APPLICATION NO: 24/00150/FUL/ADDINF

DESCRIPTION: Proposed single and double storey extension and addition of windows to side elevation following the demolition of the existing single conservatory.

LOCATION: 1 Hamlet Street Warfield Bracknell

PROPOSED SIDE ELEVATION

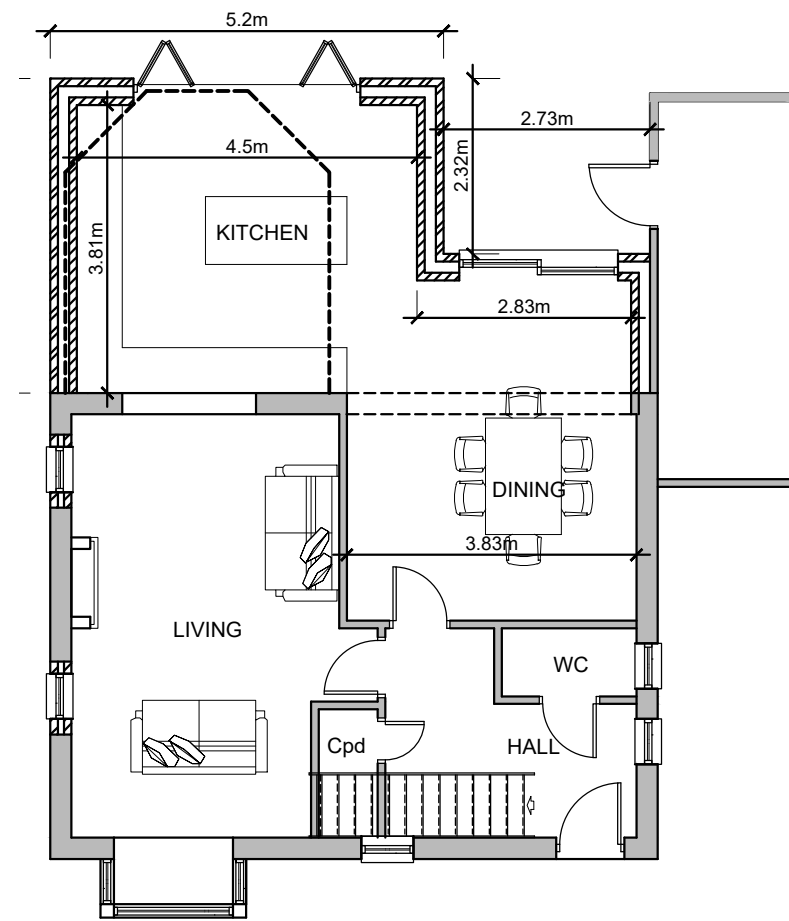
- 1 Please show the windows on the proposed right side elevation. Do not submit the plan via the portal. Please send it directly to me.
